KITTITAS COUNTY COMMUNITY DEVELOPMENT SERVICES

Subject: Swauk Valley Ranch (LPF-18-00003) Final Plat. – Staff Review and Request for Additional Information

MEMORANDUM

TO: Community Development Services
FROM: Taylor Gustafson, Environmental/Transportation Planner TG
DATE: July 30, 2018
SUBJECT: Public Works' Comments Short Plat LPF 18-00003 (Swauk Valley Ranch)
(Despite CDS labeling this as a 'LPF', this is a 4 lot Short Plat, and will be reviewed as such. Preliminary Long Plat review for this application was under LP-17-00007)

Date: 3-28-18
Scale: 1"=200'
Drawn By: JG
Surveyed By: JG/TB
Checked By: JG
Sheet 1 Of 3
Job Number: 2016-SWK

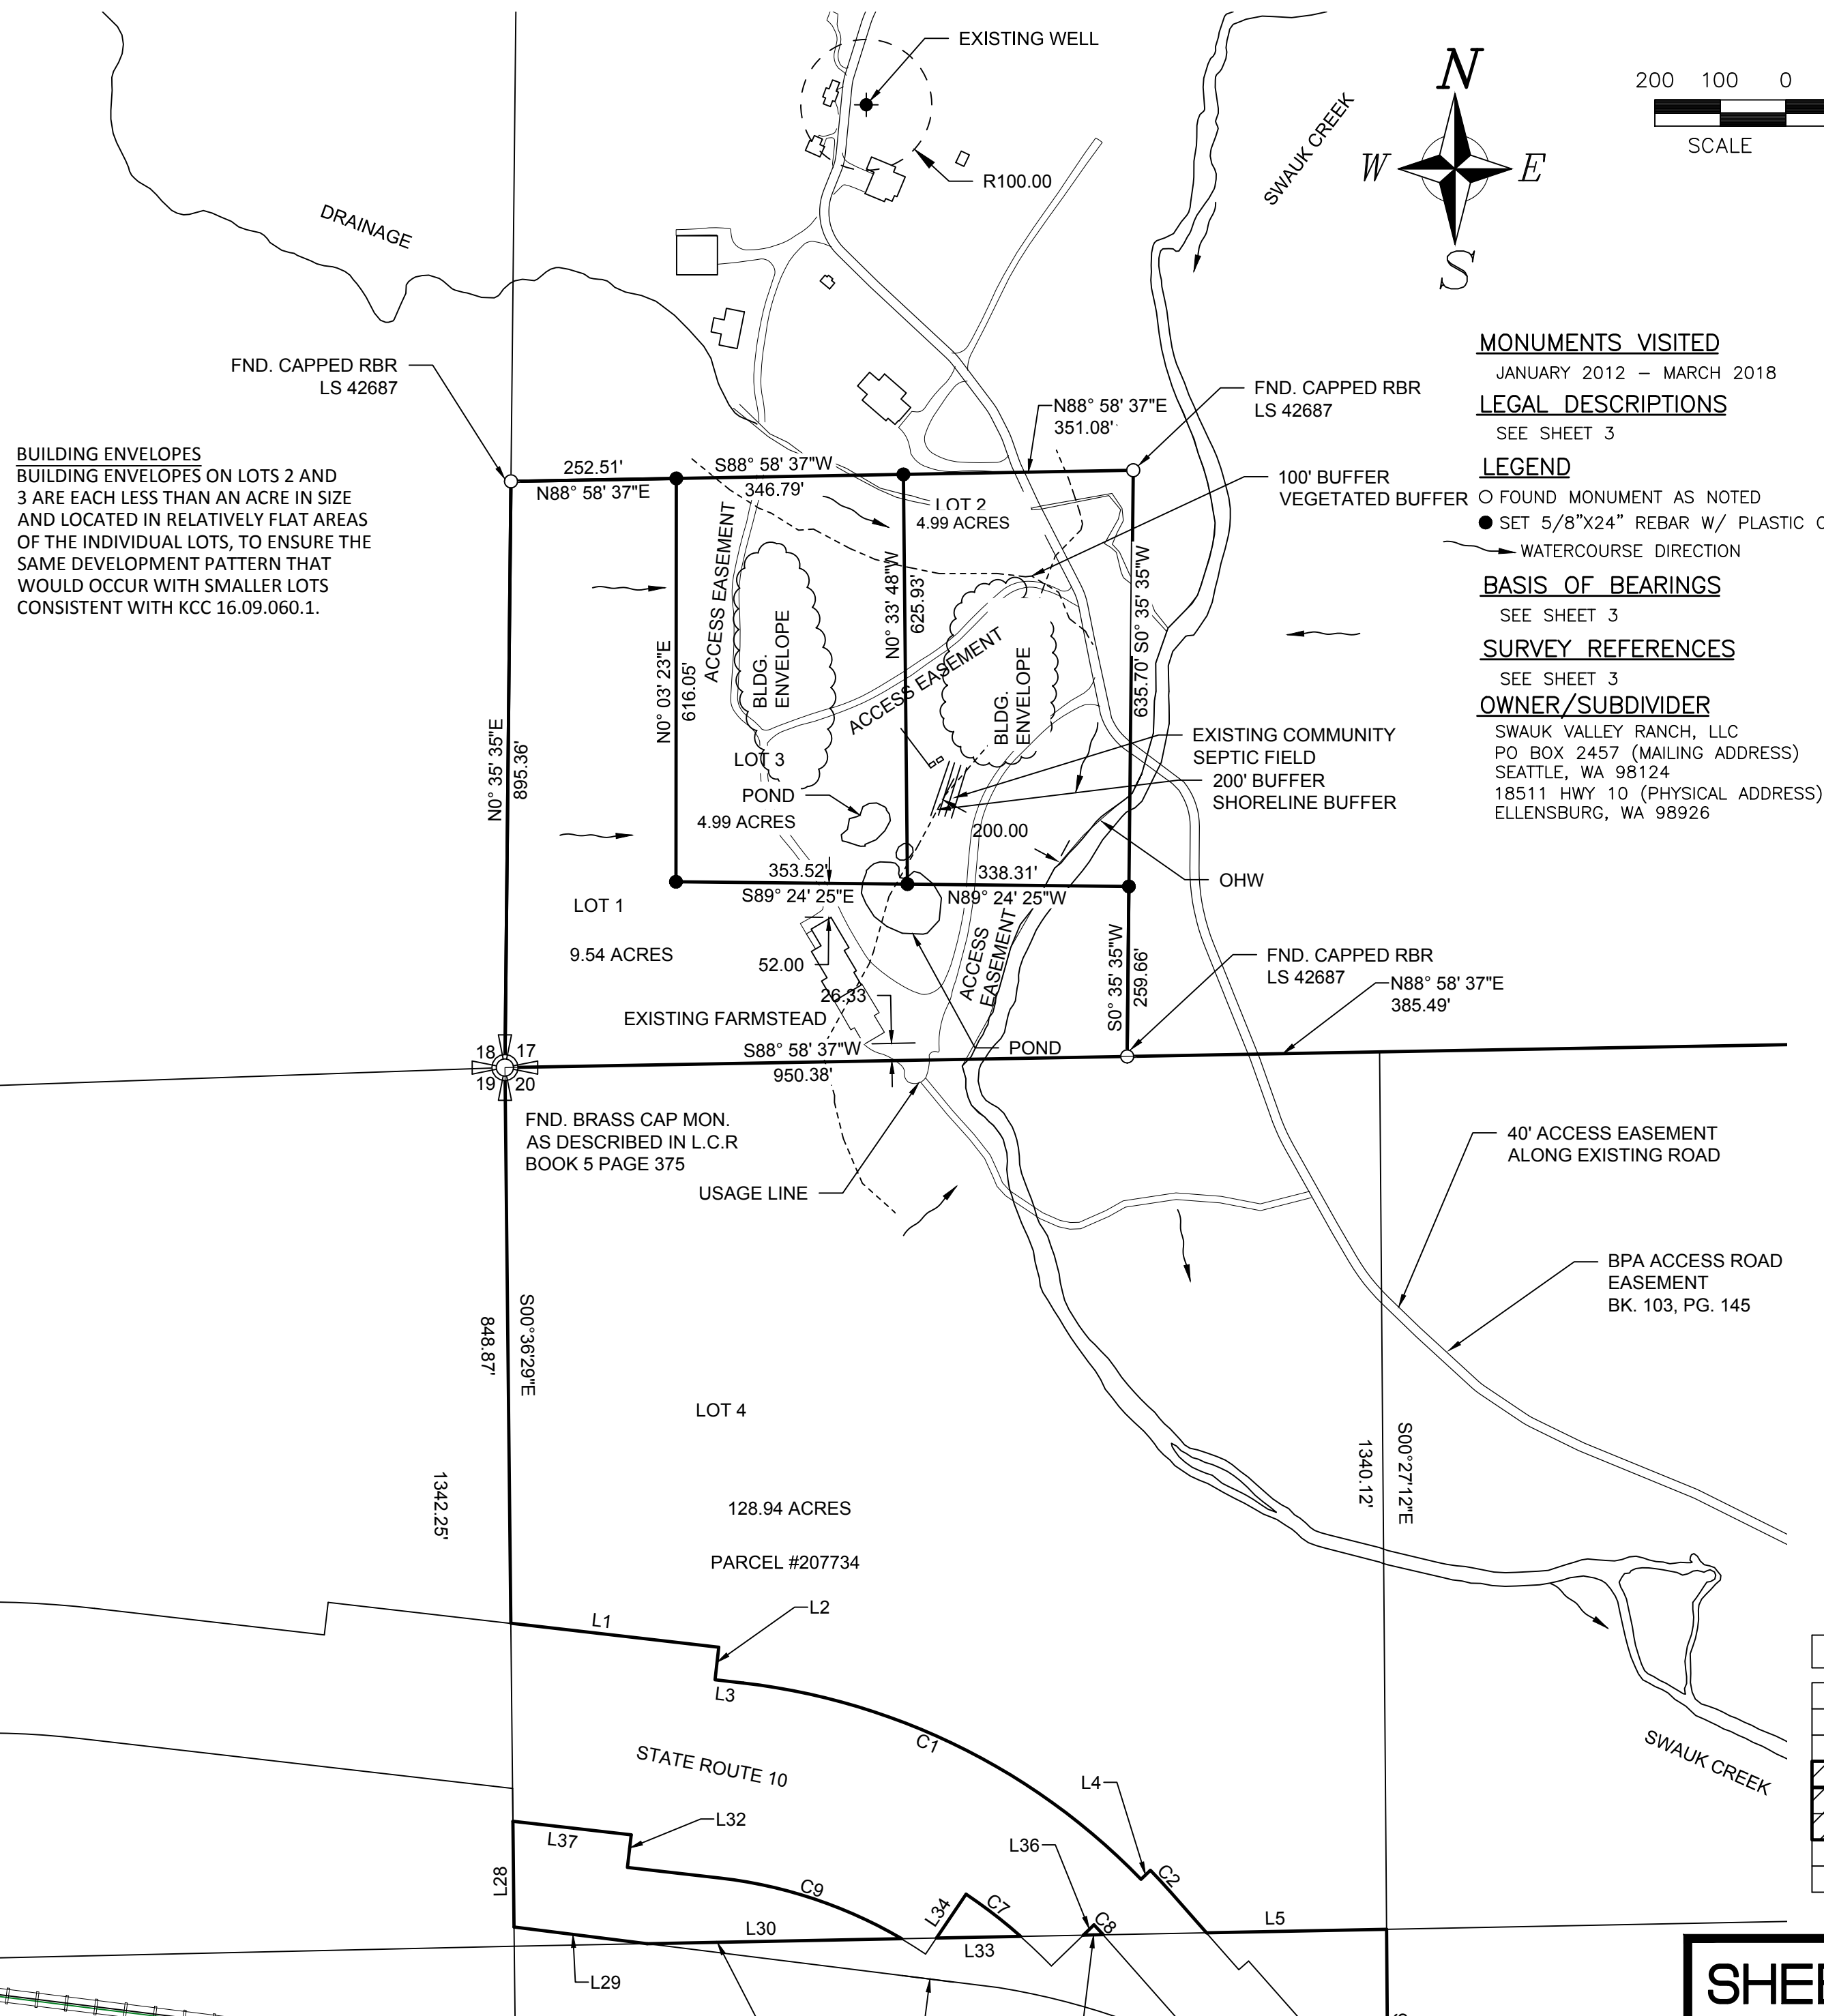
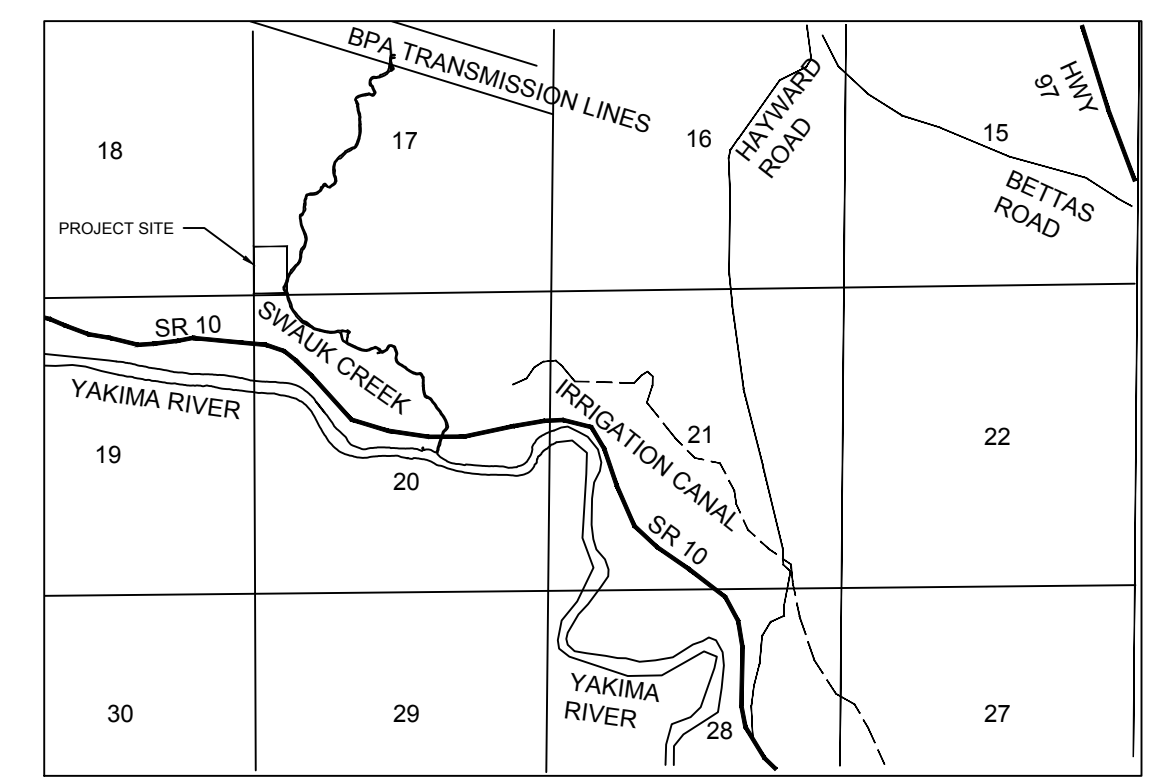
- 6) The access easement shall be addressed as existing or herein dedicated. If existing, the recording number shall be included, and if dedicated, the position shall be mathematically traceable.
- 7) The roads identified as private roads on lots 1-3 shall be revised to include easements to provide legal access to the new parcels.
- 8) The BPA access road shall be identified as where it begins and the 40' Access easement ends (or overlaps identified). The 40' Access road shall include the recording number of the easement document.

- 9) The area north of parcels 1 and 3 identified as R100.00 shall be identified. Additionally, if this well is to serve lots 1-3, easements shall be shown connecting said parcels to the well.
- 10) The building on Lot 1 shall show distances to the North and South property lines to ensure it meets setback requirements.
- 11) It appears that a portion of Lot 4 is being used by Lot 1. This usage shall be identified.
- 12) There are portions of Lot 4 that fall south of SR10. As these portions are a part of the land to be divided, they shall be delineated. The railroad right of way may also contain a small sliver of the largest undelineated parcel.
- 13) One of the corners of Lot 3 shows it as being set in a pond.

Sheet 3 Of 3

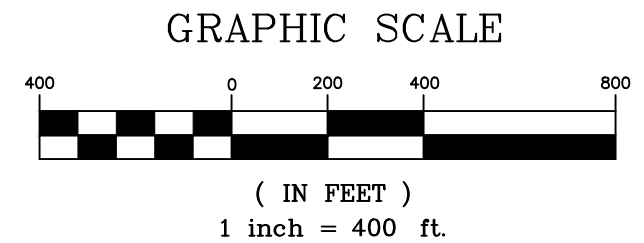
- 17) It appears the survey references are incorrect as they reference miles away from the project site, or documents that do not exist, while failing to reference the BLA that the document is clearly based on.
- 18) The Notary statement is invalid as it is not signed by the Notary.
- 19) The Owner's dedication is missing.
- 20) Board of County Commissioner's signature block is unnecessary.
- 21) County Assessor signature block unnecessary.

Sheet 2 Of 3

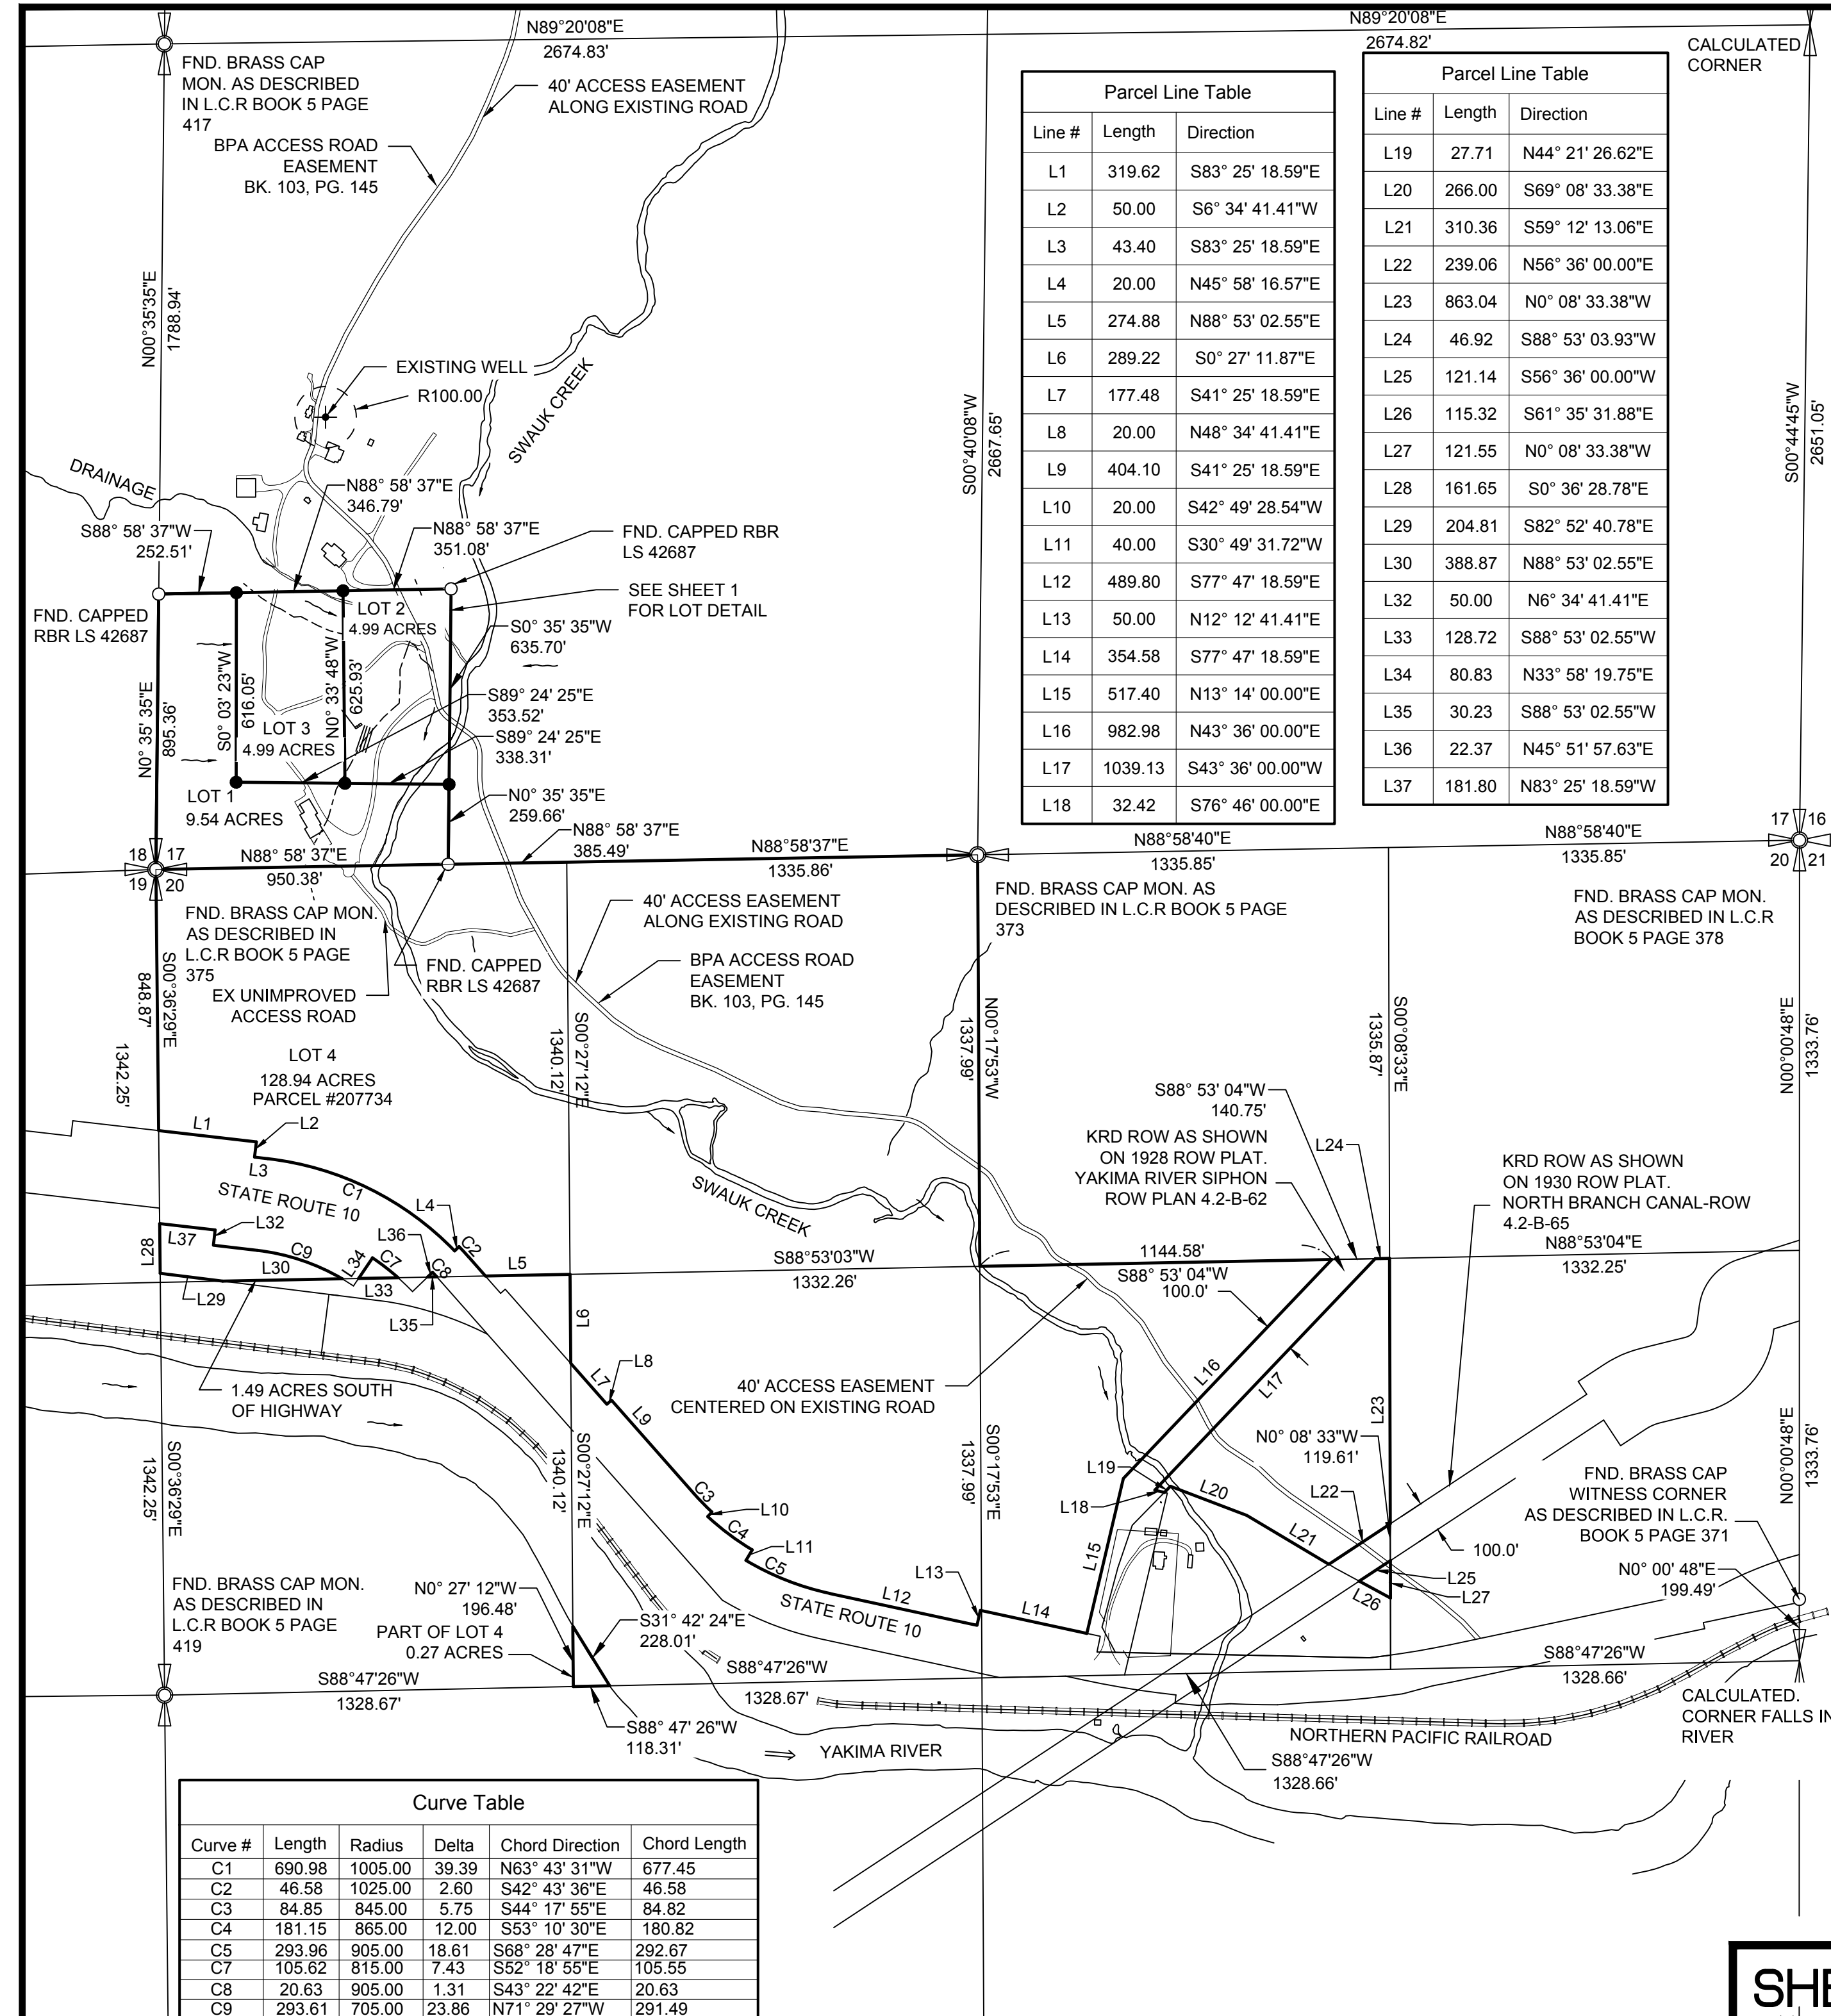
- 14) The leader arrow to the Witness corner at E1/4 of Sec 20 does not point to the witness corner.
- 15) There appears to be usage across Parcel 4 by the adjacent parcel to the East, near line 16. Usage lines shall be identified. This same parcel appears to be outlined and overlaps onto Lot 4 or the KR D r/w. This should be identified.
- 16) The closure reports do not match the radii as shown on the curve table.
